**Consultation Response from Mike Hibbert,
KC Waste Strategy(Refuse & Recycling)**

2023/93704 land northwest of, Urban Terrace, Denby Lane, Grange Moor, Huddersfield, WF4 4EB

Erection of 10 dwellings and associated works

Date Responded: 26/09/2024.

1 Proposed Site Layout

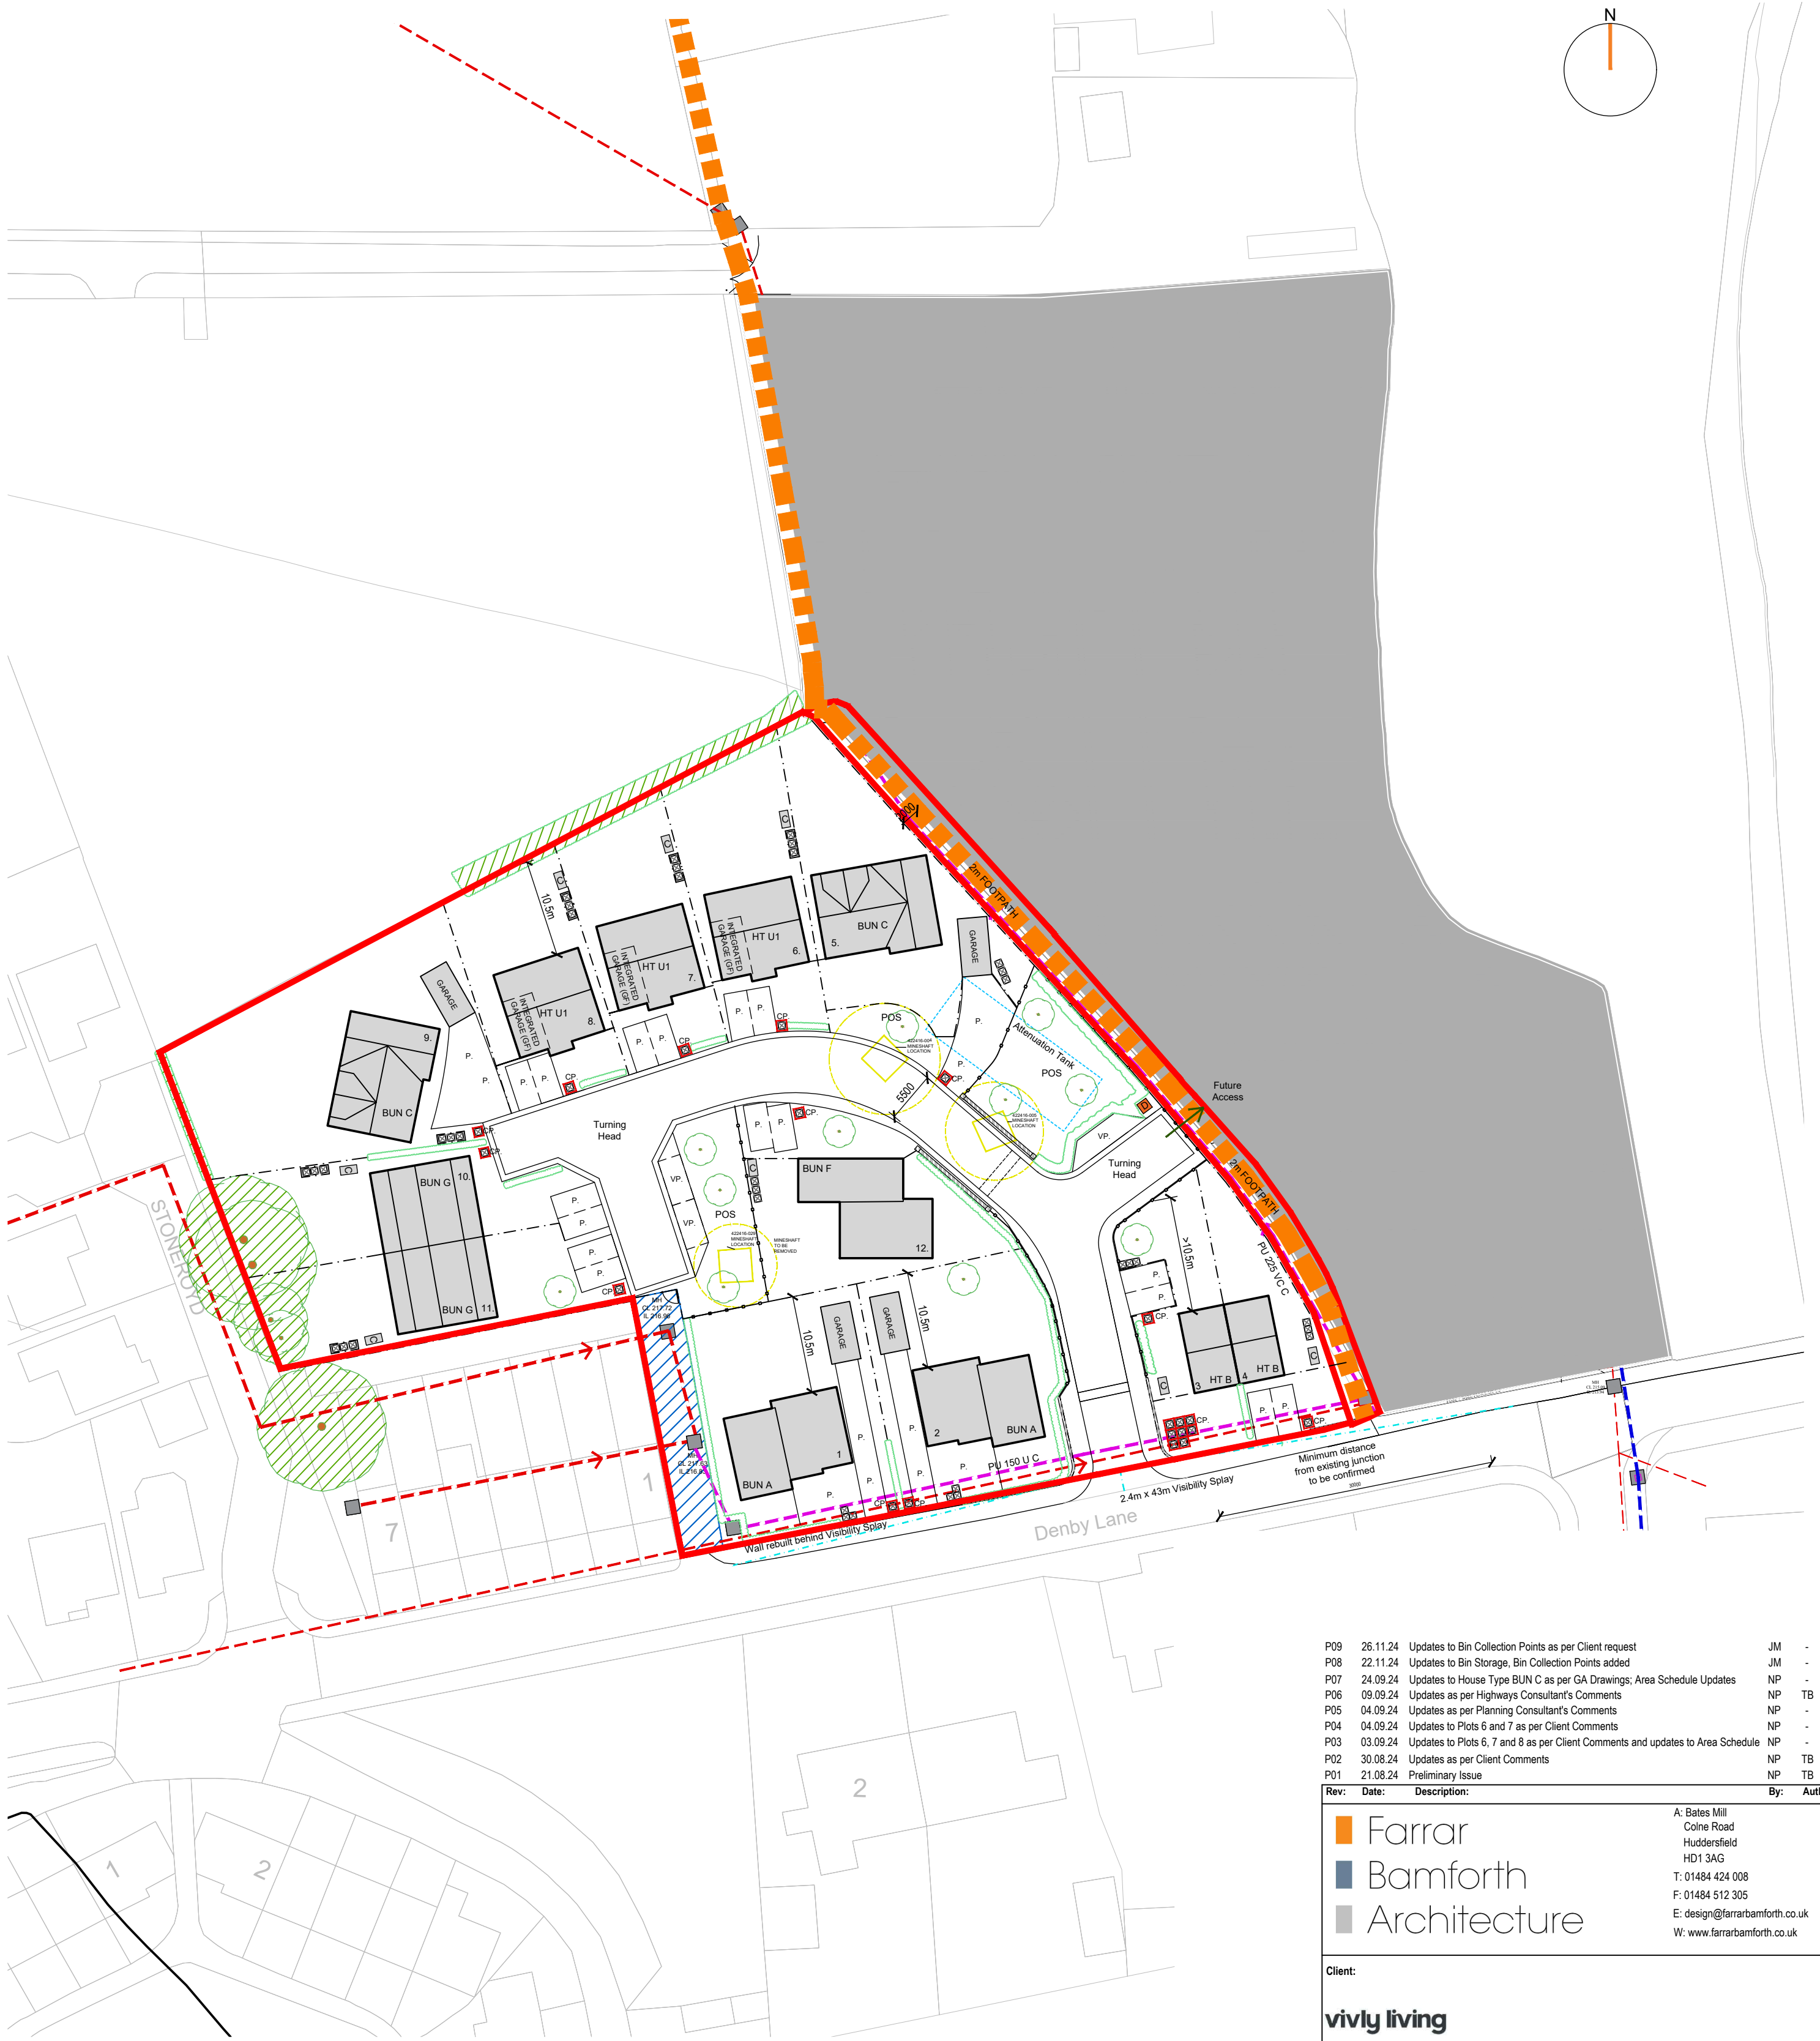
- It is welcomed that (other than plot 4) each dwelling is shown as having storage space for three wheeliebins.
- On plots 1-3 storage is shown at the front of the properties and details are requires as to the screening, as this will impact on the Streetscene.

- For Plots 5 to 12 bin storage is in the rear gardens. Gated access should be shown to be secure and the route between the rear gardens and the front access road must not require residents to pull bins up/down gradients of more than 1:12. Gates must we wide enough to enable passage of wheeliebins and space available to navigate around parked cars in driveways.

- On collection day the residents would need to transfer bins to a presentation point close to the adopted highway and not left on the footway. The Bin Collection Points should be shown on the Site Plan. Plots 1,2 and 3 can present bin within their curtilage but adjacent to Denby Lane.
